Pre-lodgement Meeting Notes

Application No:	PLM2025/0065
Meeting Date:	3 June 2025
Property Address:	36 Cabbage Tree Road BAYVIEW
Proposal:	Demolition works and construction of a residential care facility
Attendees for Council:	Nick Keeler, Planner Daniel Milliken, Manager Development Advisory Service Catriona Alder, Waste Planning and Compliance Officer David Hellot, Senior Environment Officer - Catchments Belinda Morgan, Acting Senior Environment Officer - Catchments Dominic Chung, Senior Urban Designer Finola Sturrock, Senior Urban Designer
Attendees for applicant:	Chris Forrester Sarah Castro Corey Taylor Tyron Nicholson Harry Bate Lara Caulder Bradley Wahl

LANDSCAPE AREA CALCULATION

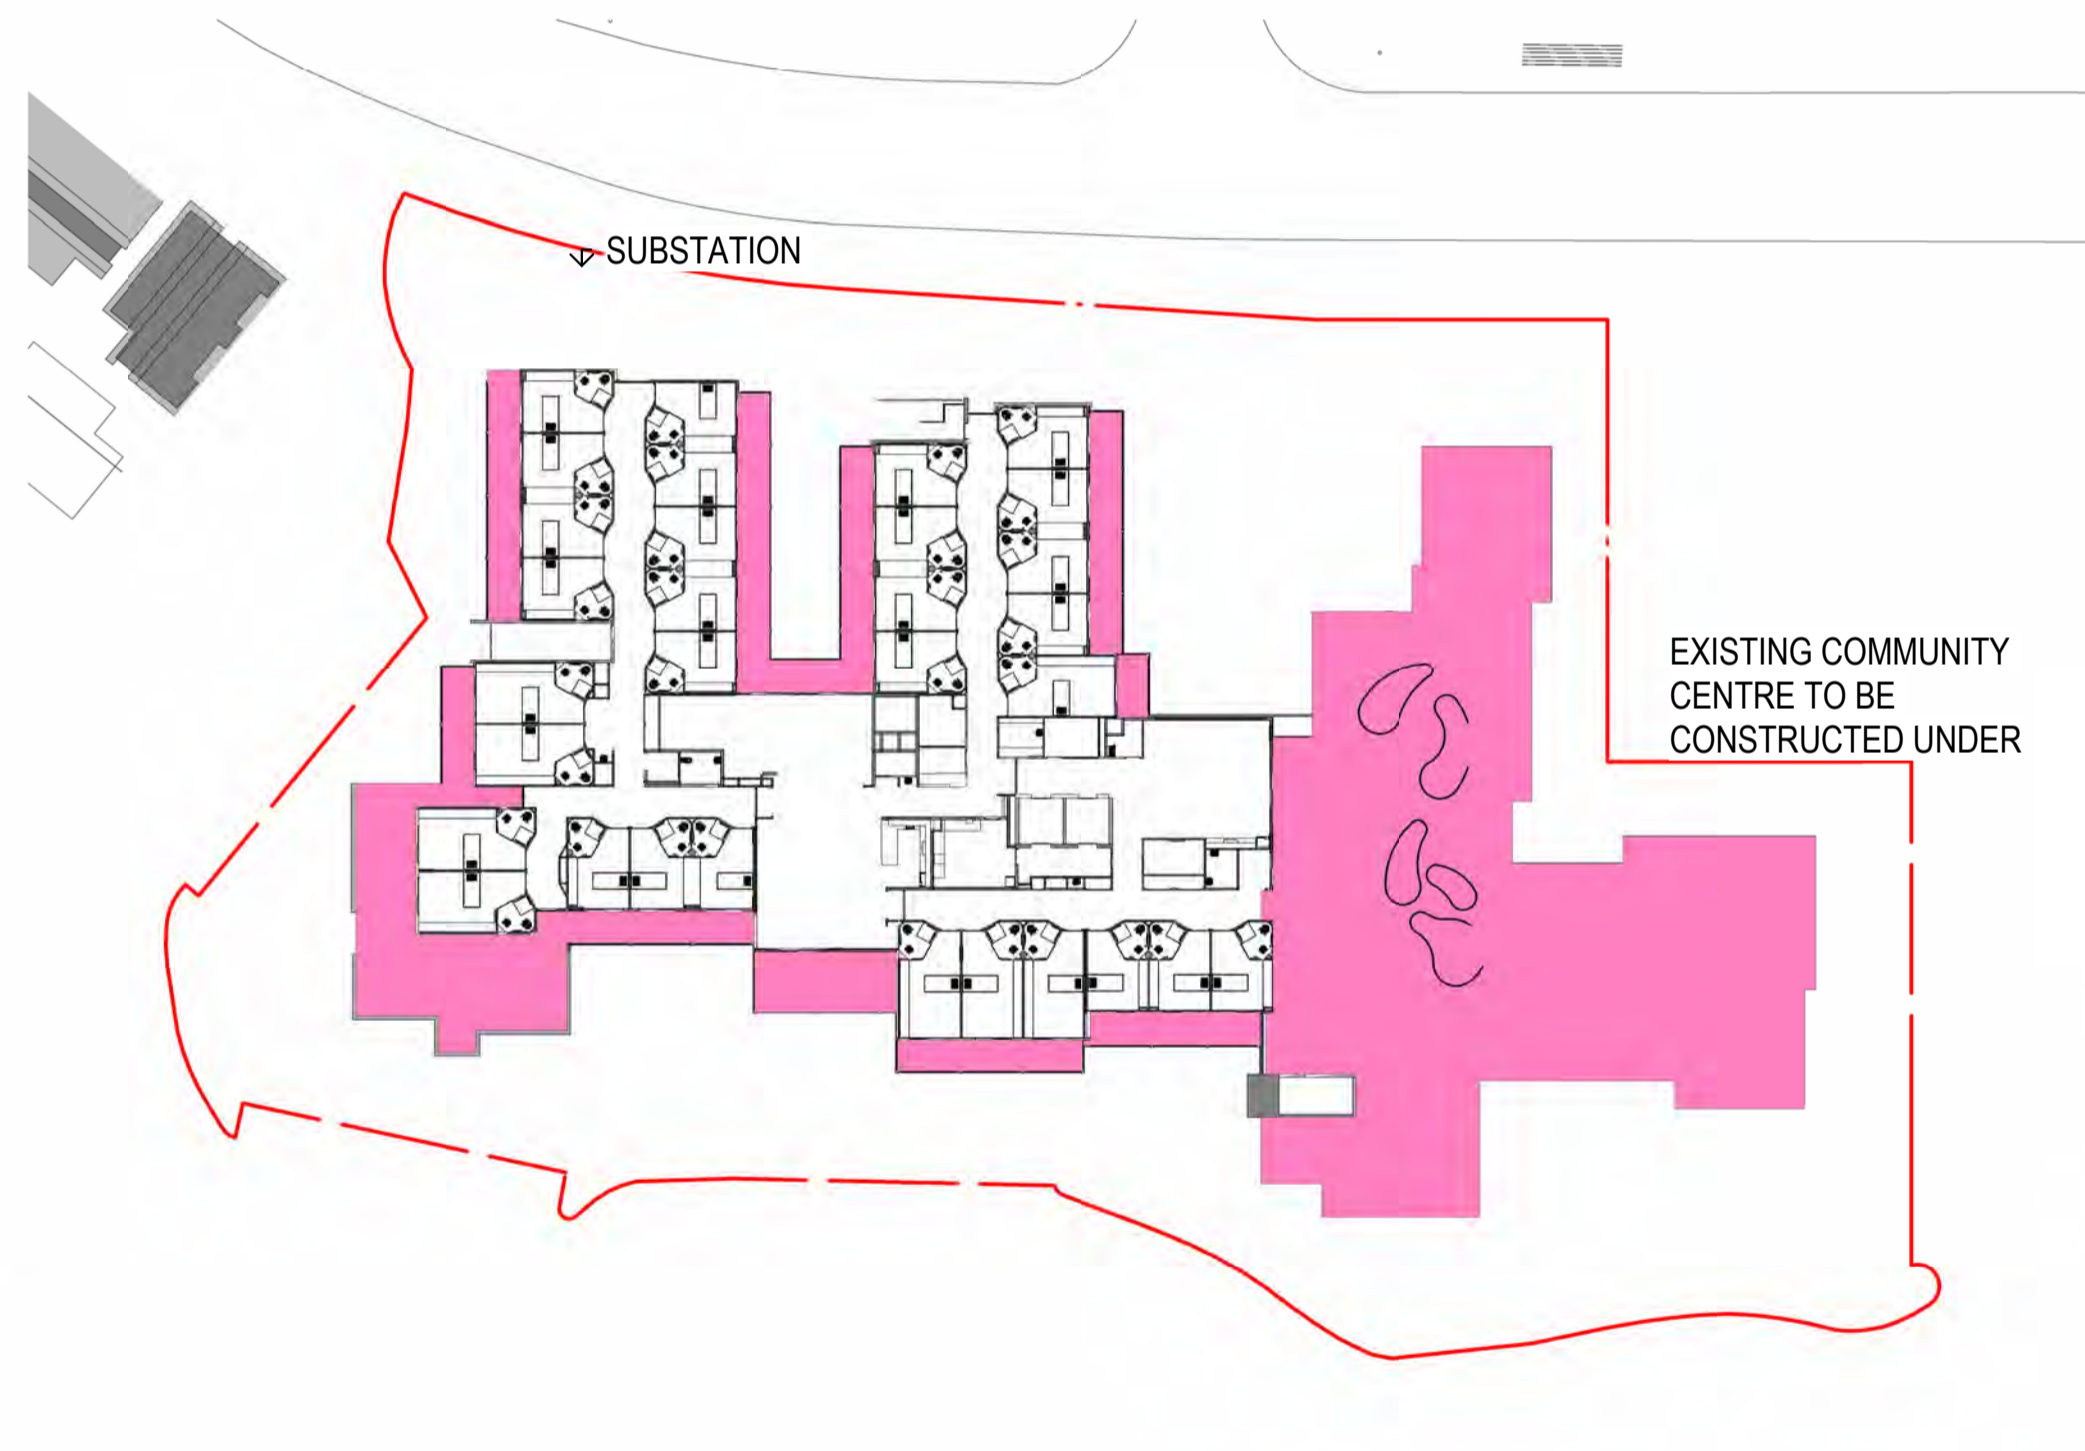
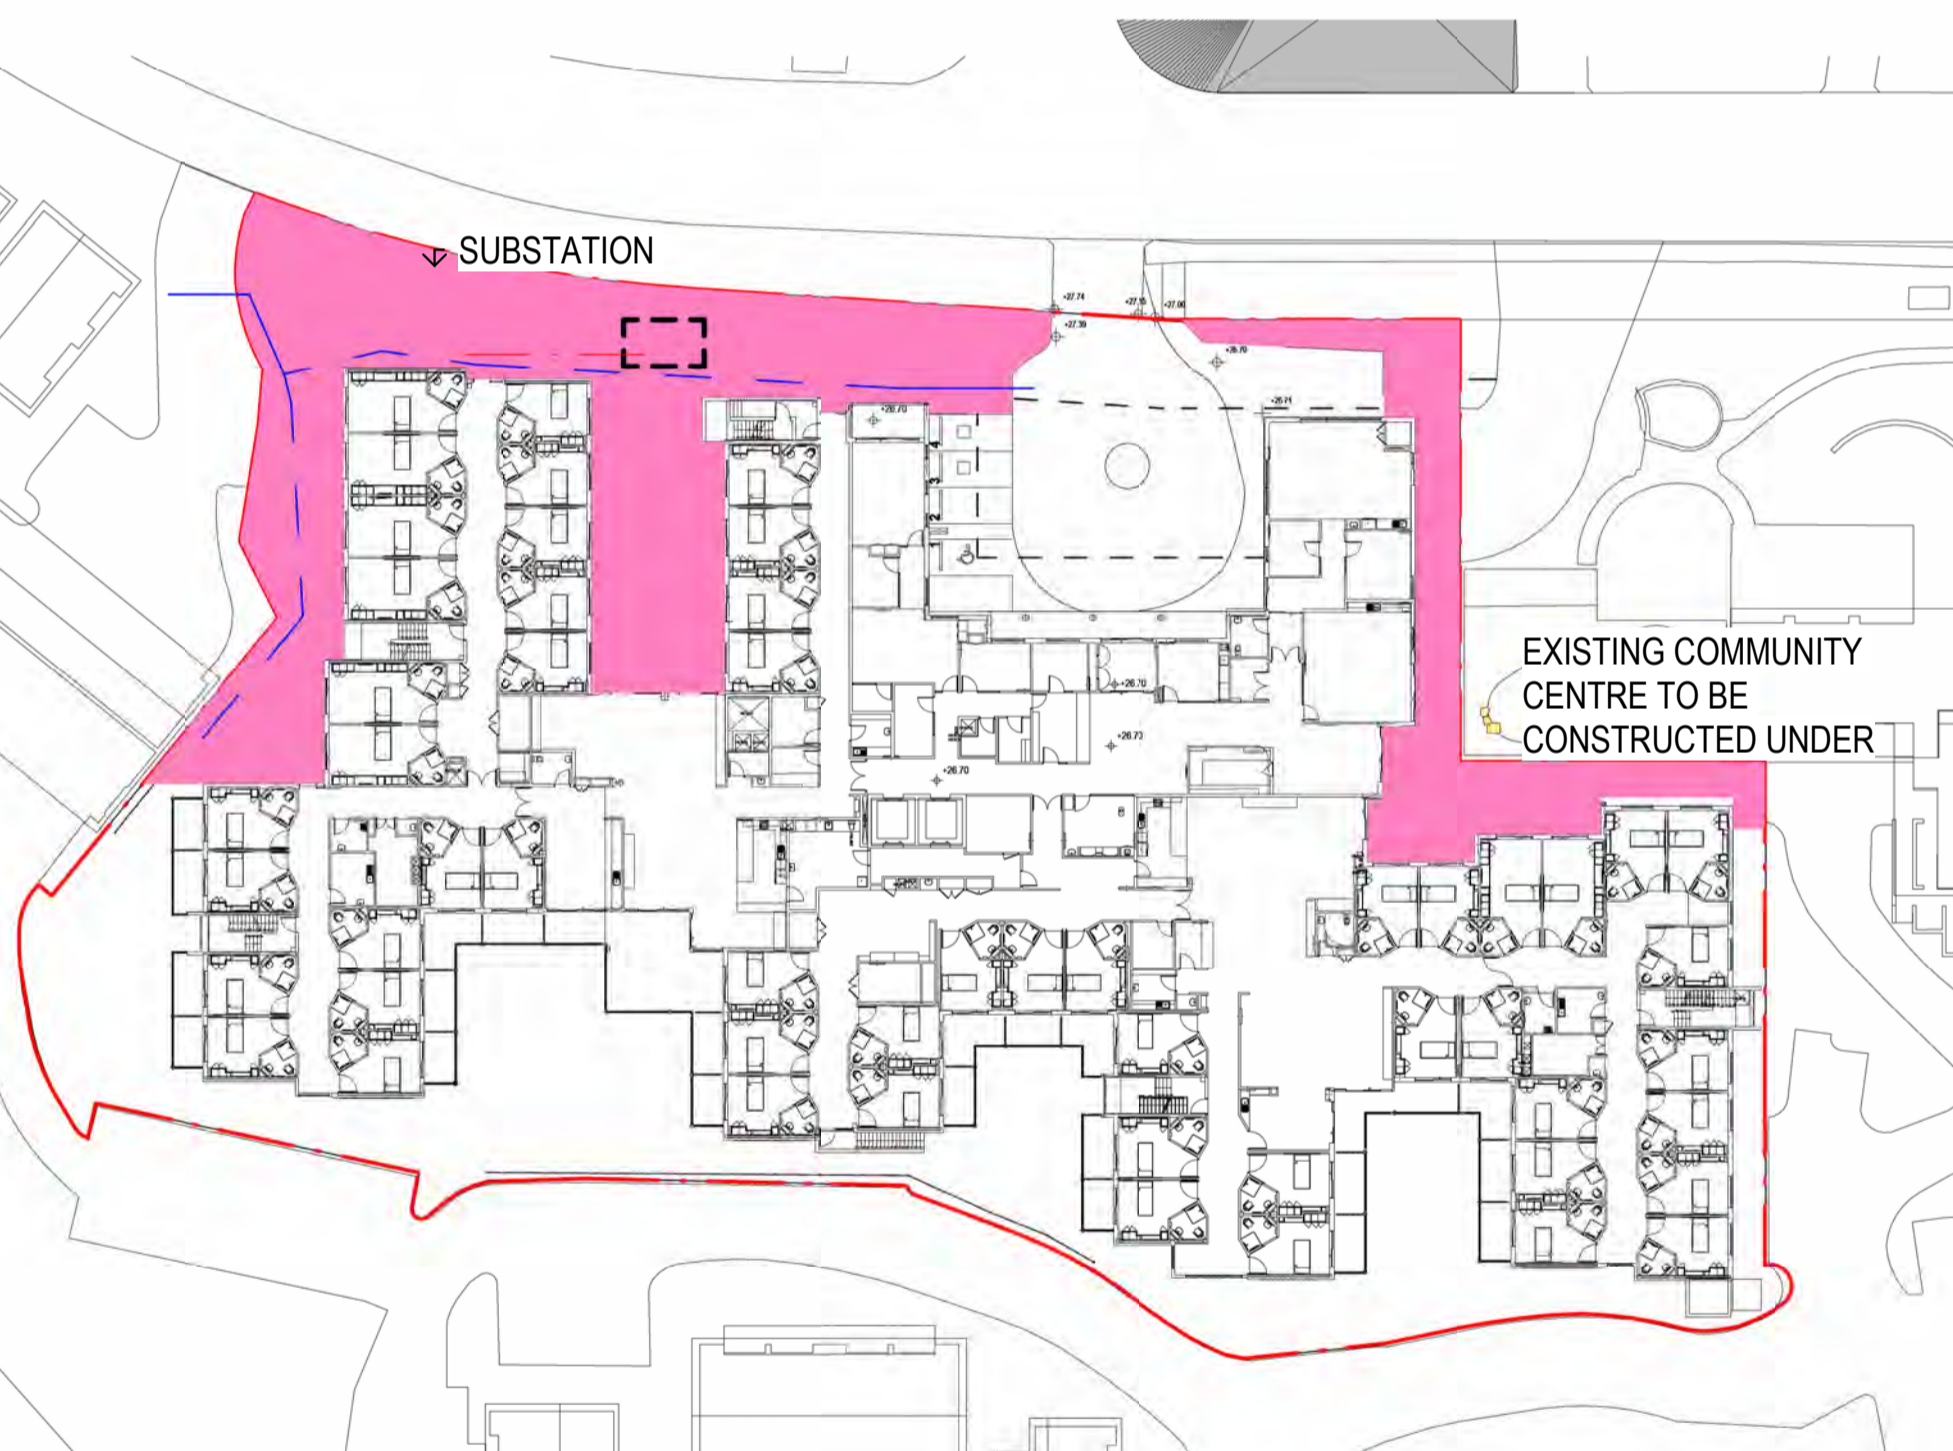
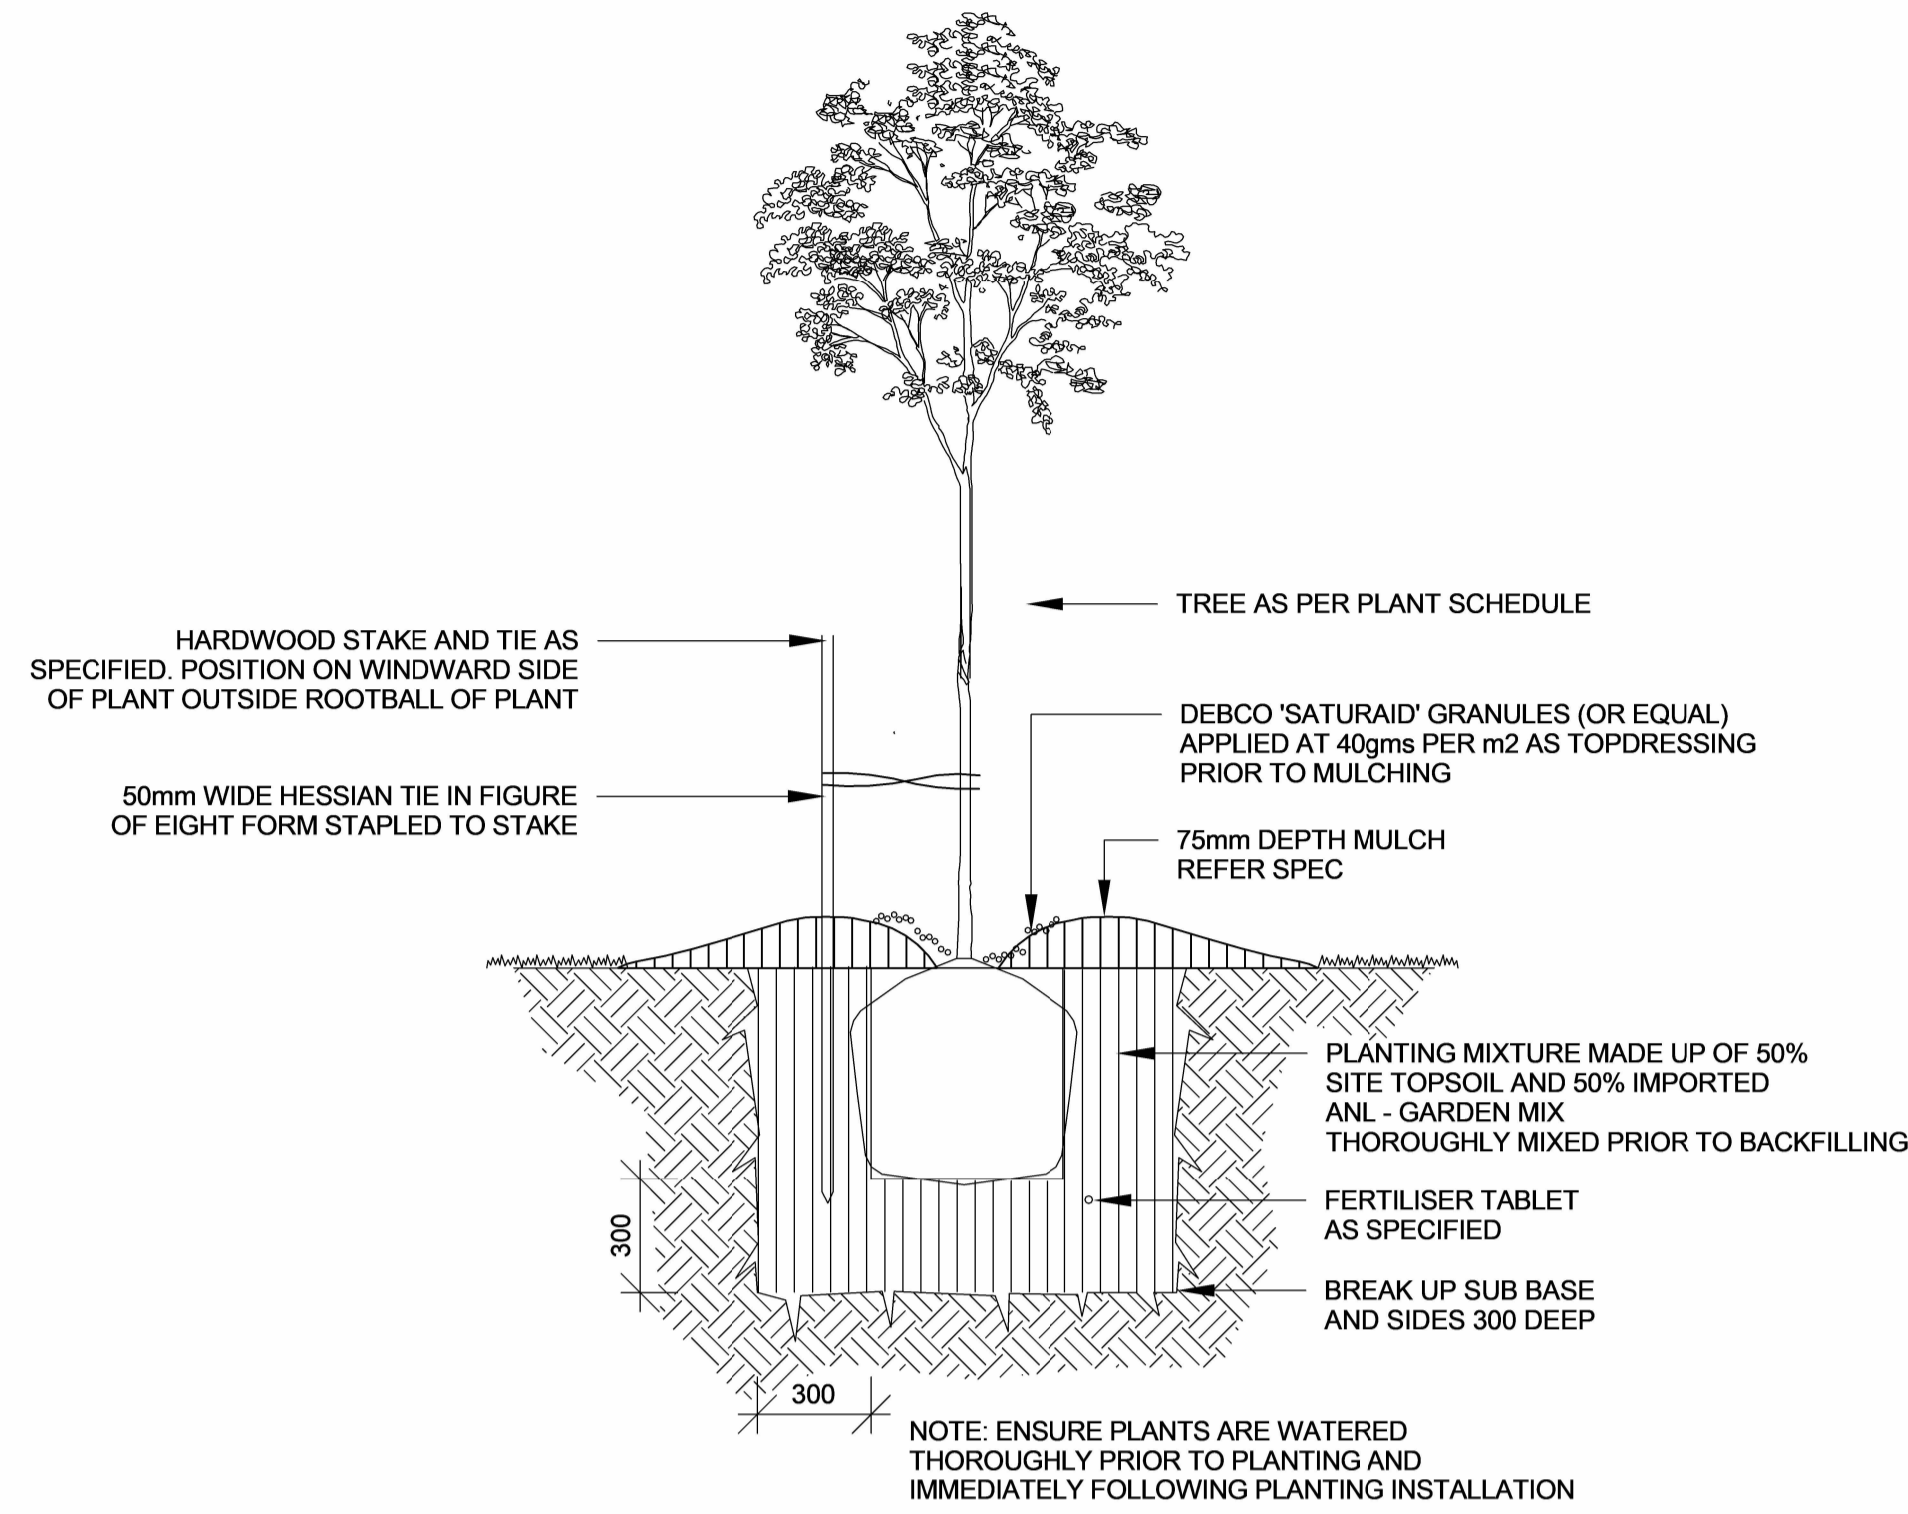
Total internal and external communal open spaces of 10m ² per bed	Area schedule not provided	Unclear
	Minimum 15m ² landscaped area per bed	Area schedule not provided	Unclear
	Minimum deep soil area of 15% site area with dimensions of 6m	Area schedule not provided	Unclear
	1 parking space per 15 beds	52 spaces in basement	Complies
	1 parking space per 2 on duty employees	On duty employee number unknown	Unclear
	1 ambulance parking space	1 space provided, should be marked on plan for clarity	Complies
